Your Ref: OWPC14645
Our Ref: A/121/17/HH 21-06-2017
Please ask for:
Mrs A Gardner

Town & Country Planning Act 1990 (as amended)
Town & country Planning (Development Management Procedure) (England) Order 2015

Detached double garage & single storey extensions to existing garage.
Harcourt West Drive Angmering

PROPOSED ELEVATIONS NEW DOUBLE GARAGE

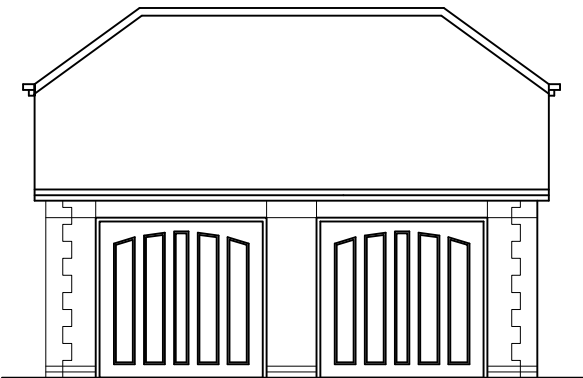
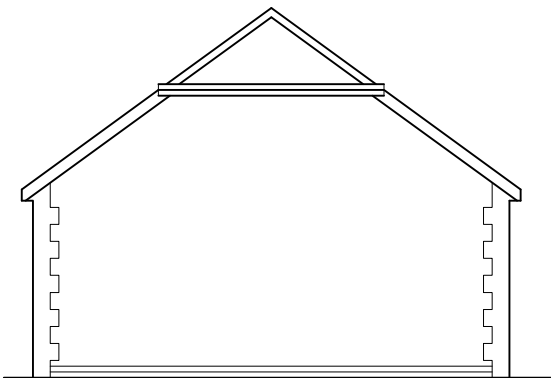
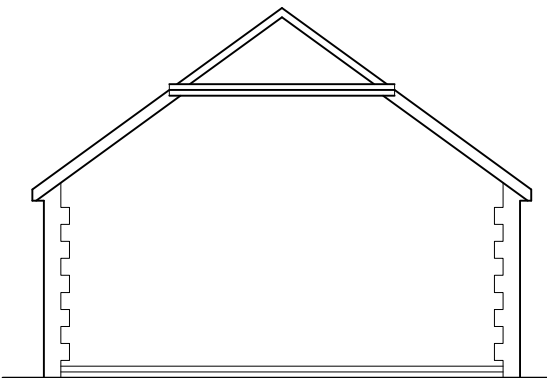
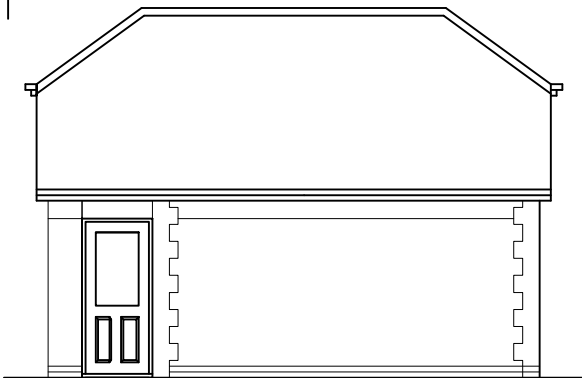
As a frequent guest of Ham Manor home owners, I have a great appreciation for the beauty of the neighbourhood and have a strong objection to the proposed construction hereunder. This structure would change the essential appeal of the area in that it appears to be out of character and would replace a long standing garden space. Respectively submitted, KU
